Re – Application number AW/344/14/HH, 68 The Drive, Aldwick.

I wish to register my objection to the developments proposed in the above application as they are not in keeping with the development requirements within the conservation area.

SOUTH & EAST ELEVATIONS
EXISTING & PROPOSED.

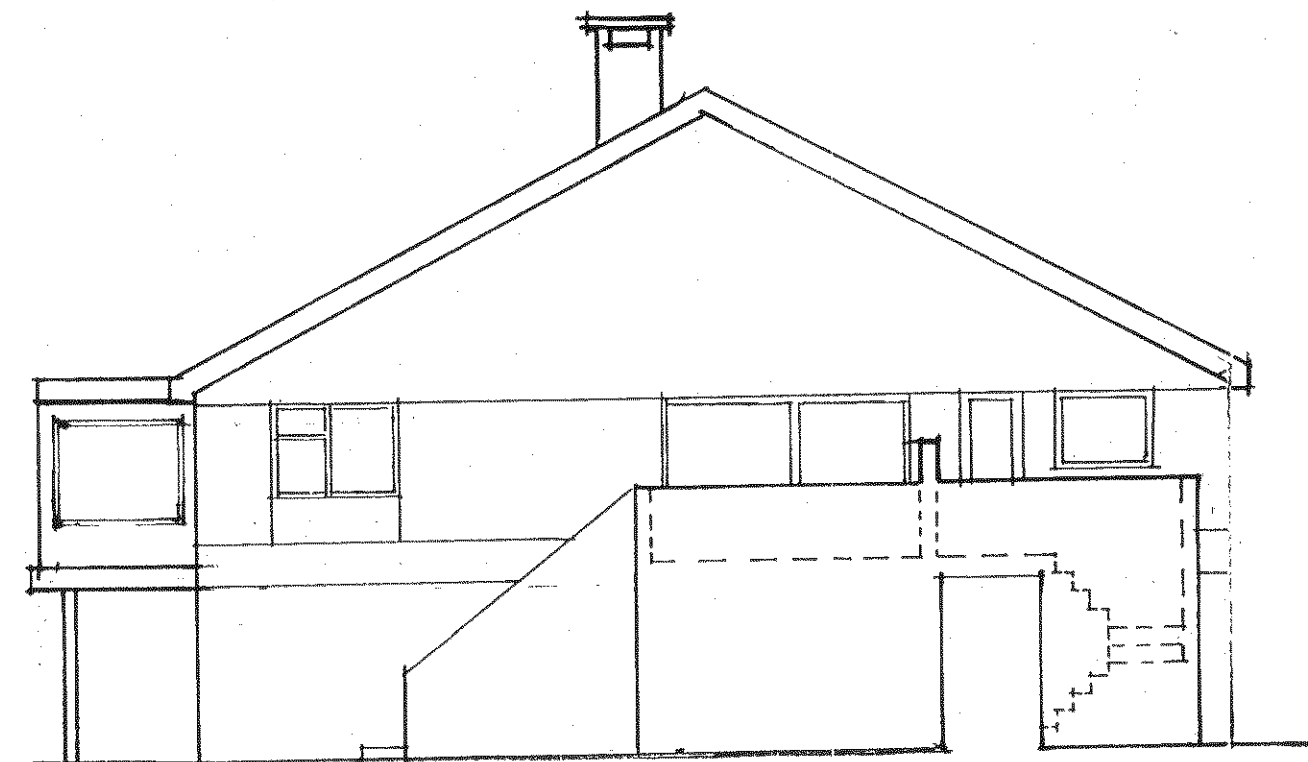
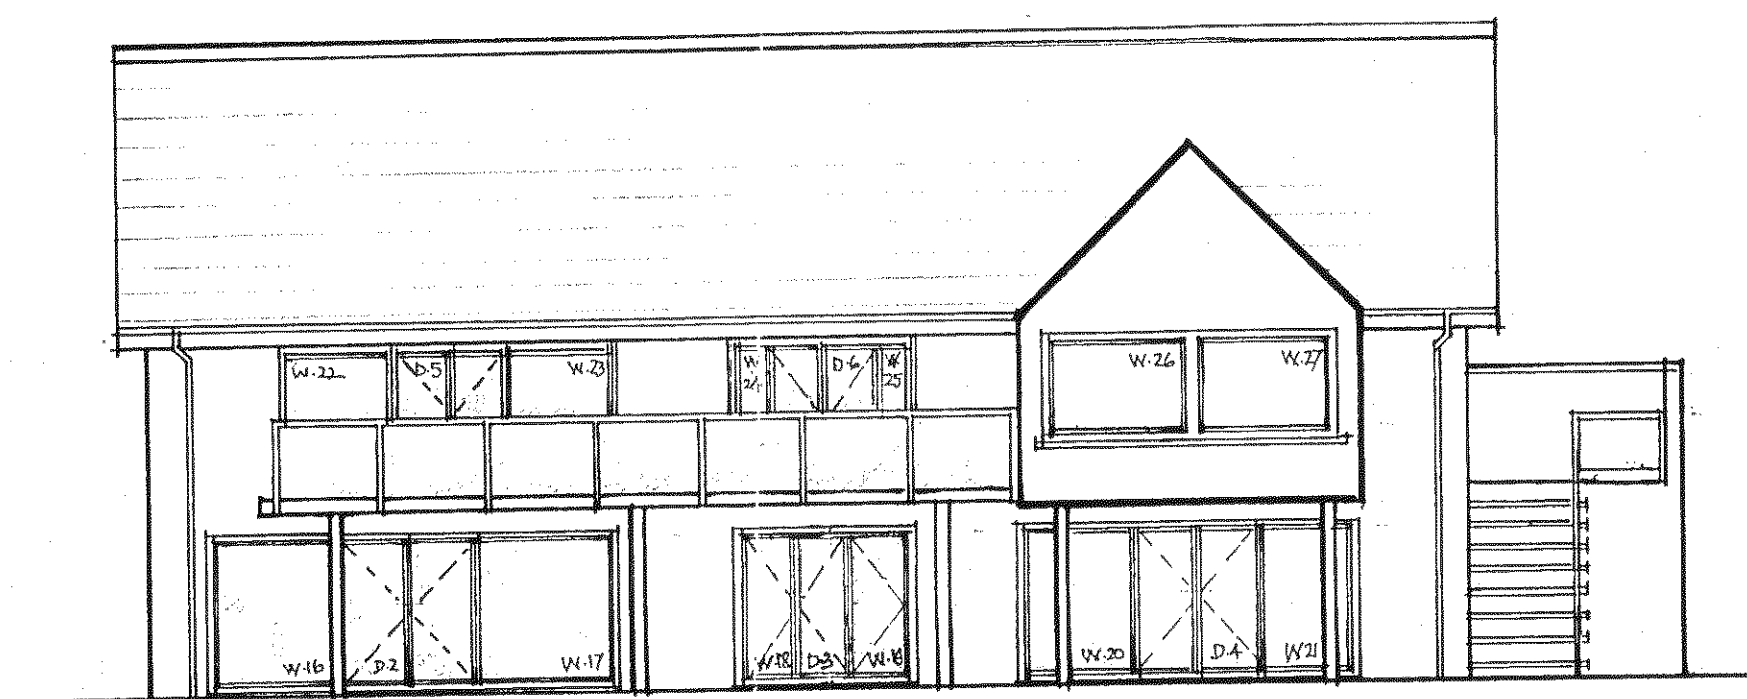
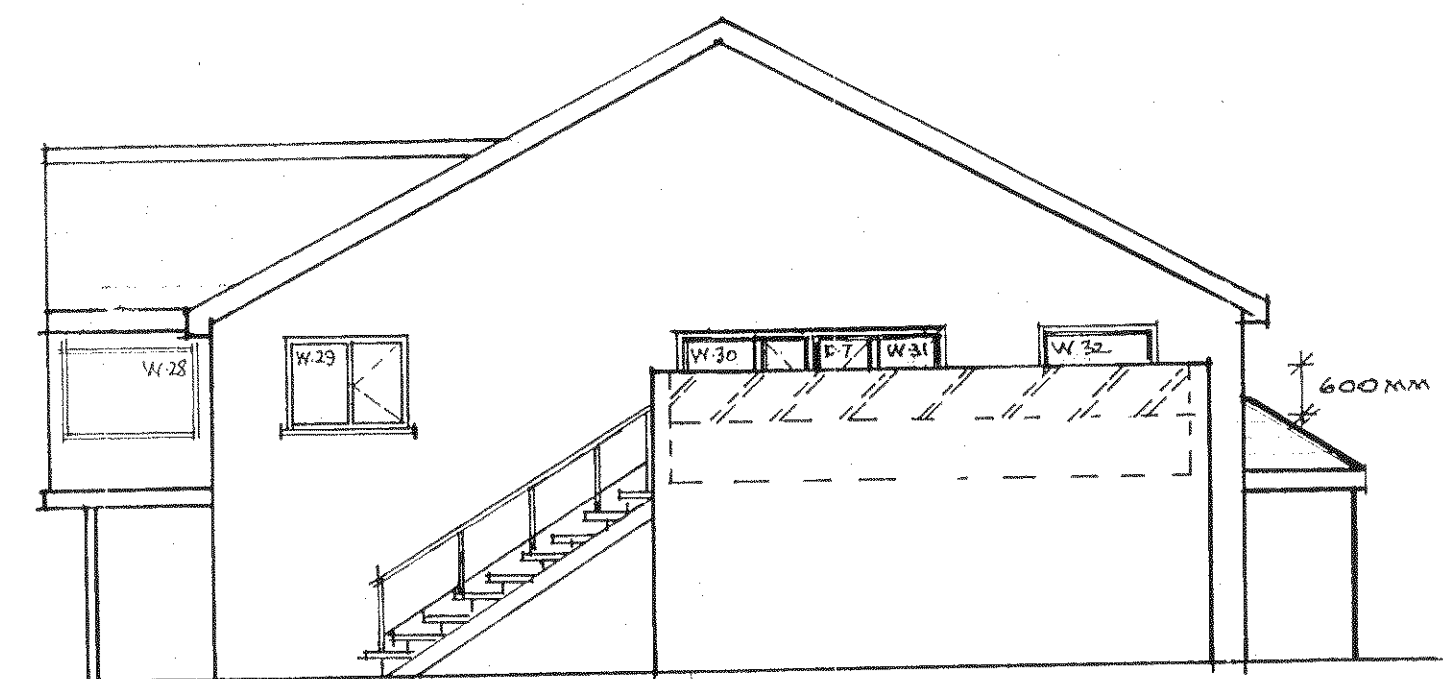
In particular the removal of the staircase to the south elevation and the replacement of the brick built staircase on the eastern elevation with a stainless steel and glass staircase is likely to increase movements of people close to the adjacent property and to make them more visible and will be a further intrusion into the privacy of the owners of number 70. The Conservation Area Plan makes reference to the spaciousness between dwellings being a characteristic of the estate, the creation of a larger terrace area will further reduce the spaciousness. The situation would be considerably improved if the external staircase and the terrace area were removed completely being replaced either by an access inside the building, or a simple enclosed staircase still on the eastern elevation or better still retaining the staircase on the south elevation as the sole external means of moving from ground to first floor level. This latter would indicate that the developer was mindful of the impact of the renovations on the neighbours as well as improving the spaciousness between the properties, which is to be desired and would make a positive contribution.
